OBSERVATION/SUBMISSION TO PLANNING APPLICATION

Case Reference: 324113

Re: Observation to the proposed development of open-cycle gas turbine (OCGT) and generator with ancillary equipment.

Location: Pollnagroagh and Rathmorrissy (Townlands), Athenry, Co. Galway

Purpose		PLANNING			
Title		SITE ACCESS SIGHTLINES			
Original Scale	Design/Drawn	Checked	Authorised		
SHOWN at A1	PS	ND	AJB		
Date	Date	Date	Date		
01.12.25	01.12.25	01.12.25	01.12.25		
Status	Drawing Number	Rev			
A2	PEK3-ATK-ZZ-01-DR-CE-901200	0

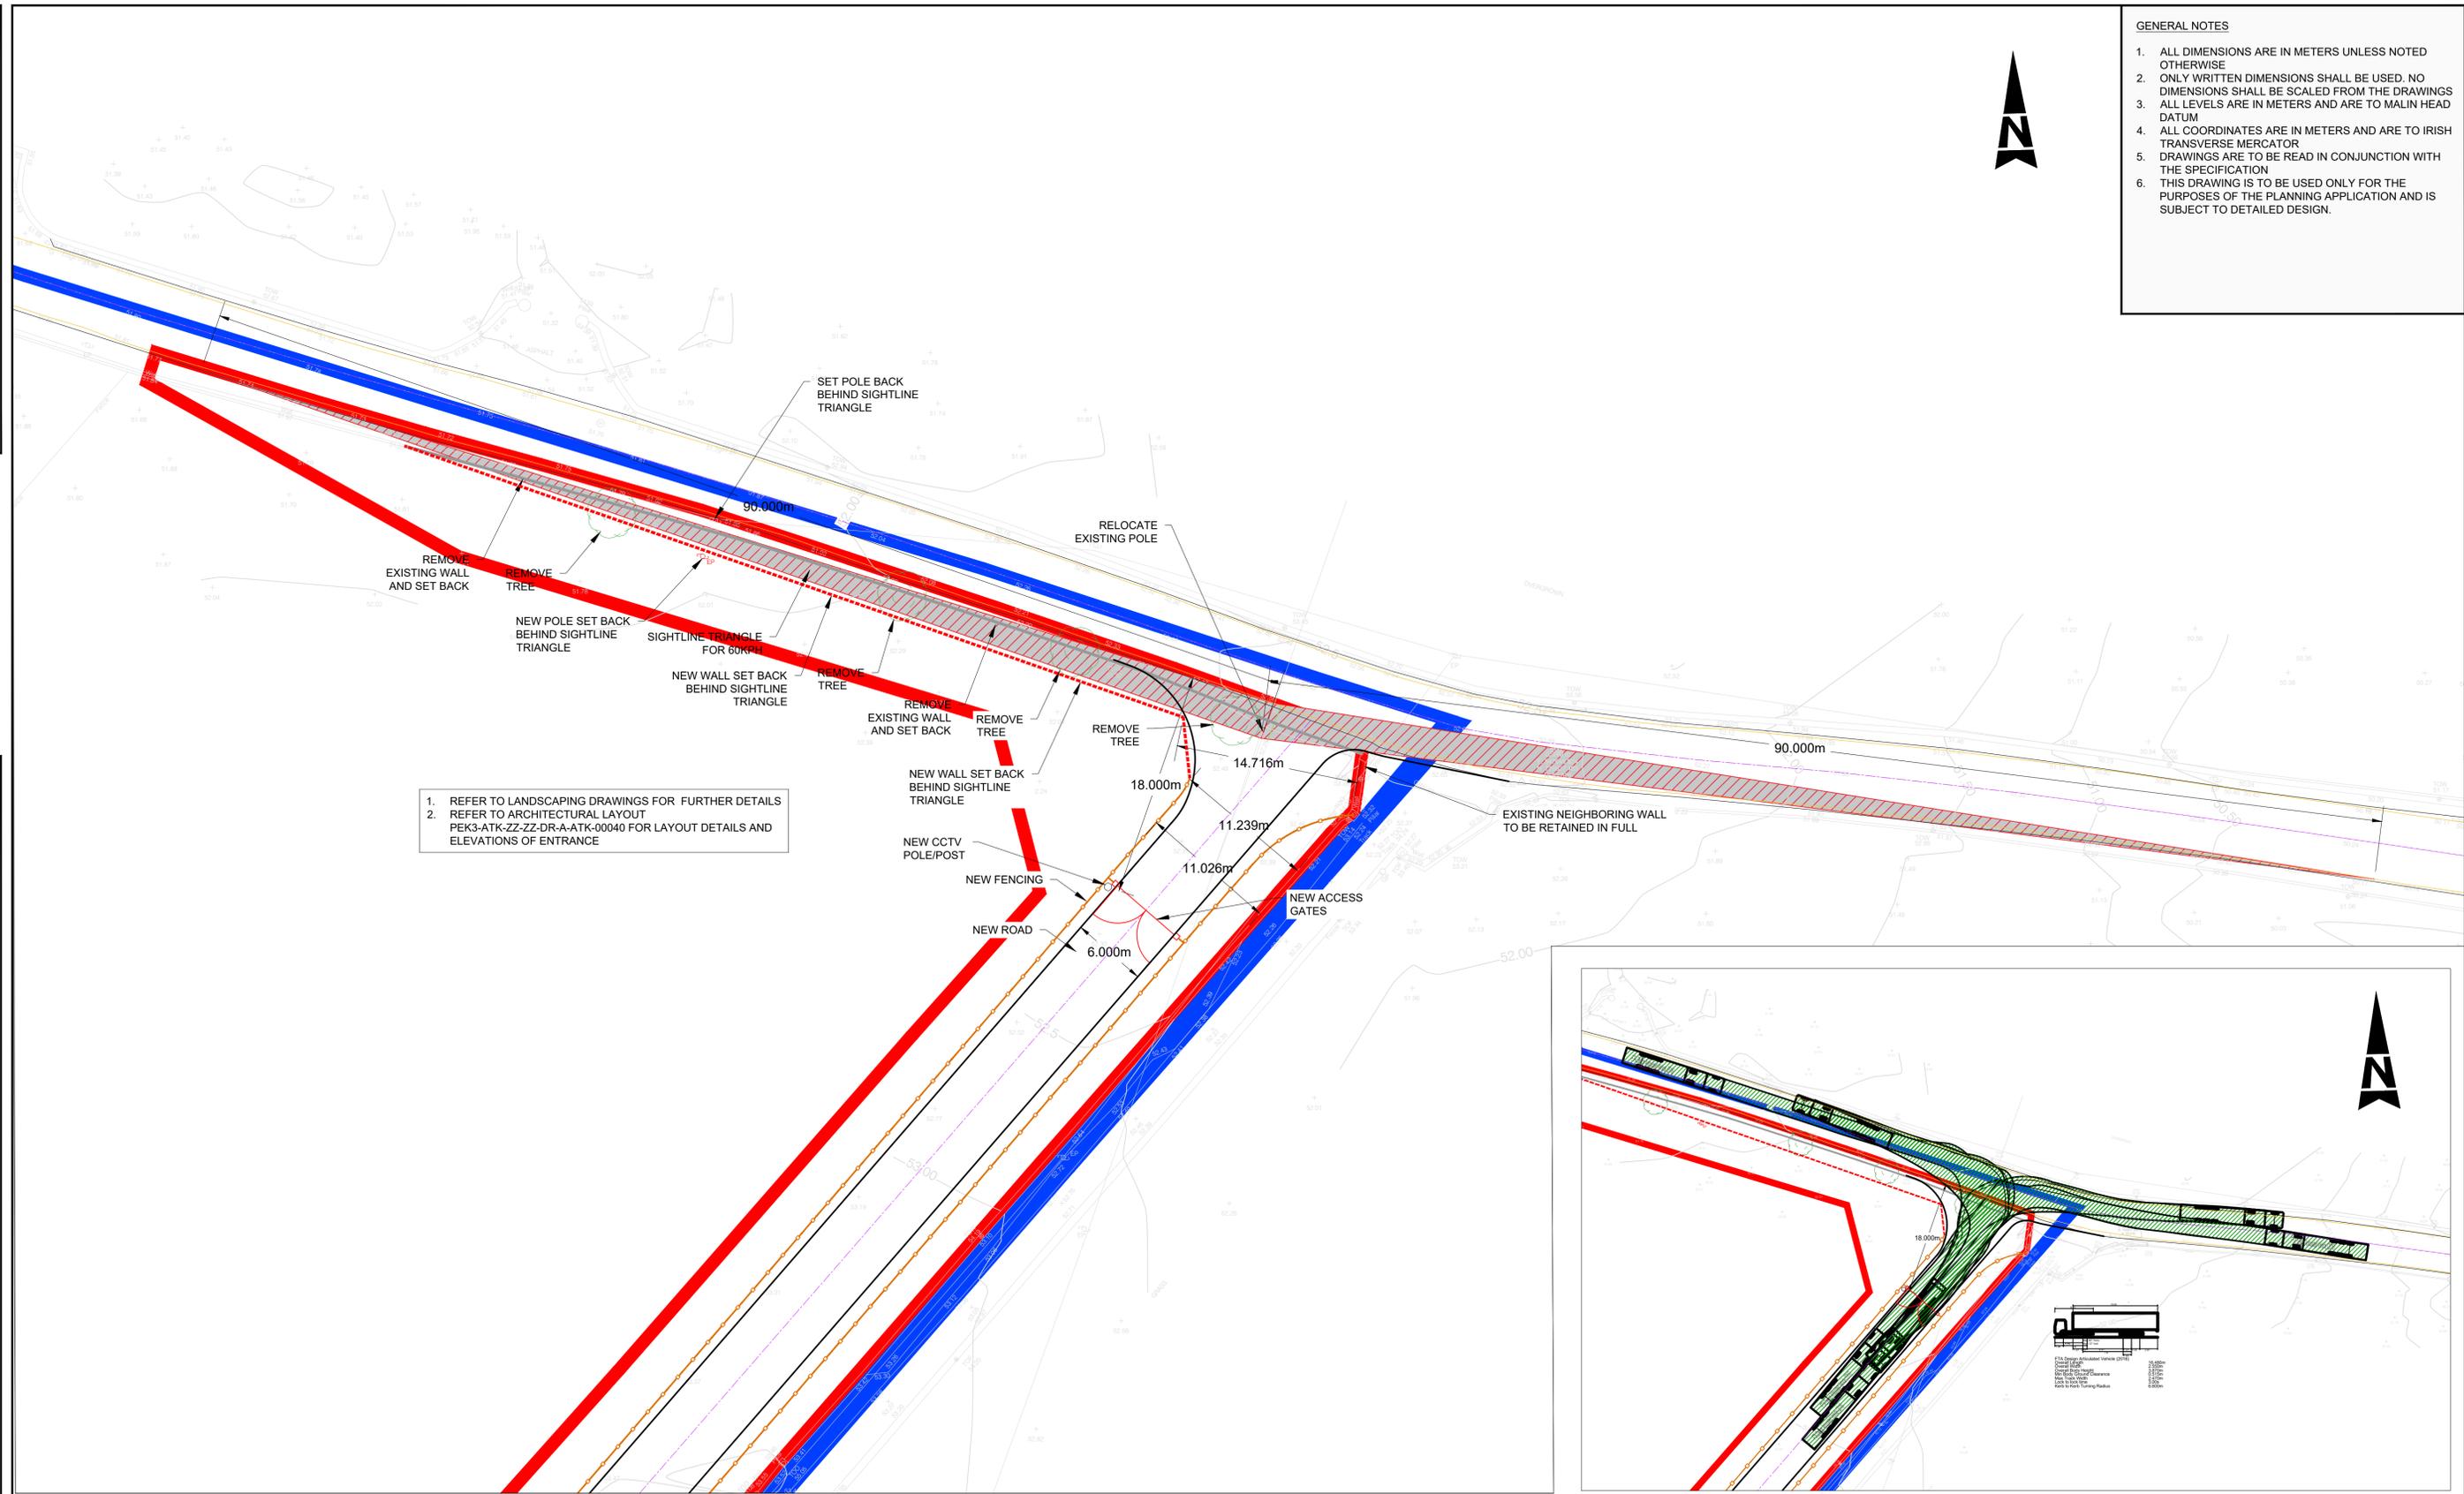
The placement of the proposed site entrance on the L3103 raises severe safety concerns due to the inherently hazardous nature of this specific stretch of road. The carriageway is critically narrow, struggling to safely accommodate two passing Heavy Goods Vehicles (HGVs), and completely lacks a hard shoulder to allow for any margin of error. Compounding these dangers are the presence of blind dips and corners, which significantly reduce visibility and sightlines for all road users. These critical safety deficiencies create an unacceptable traffic hazard that must be comprehensively addressed.
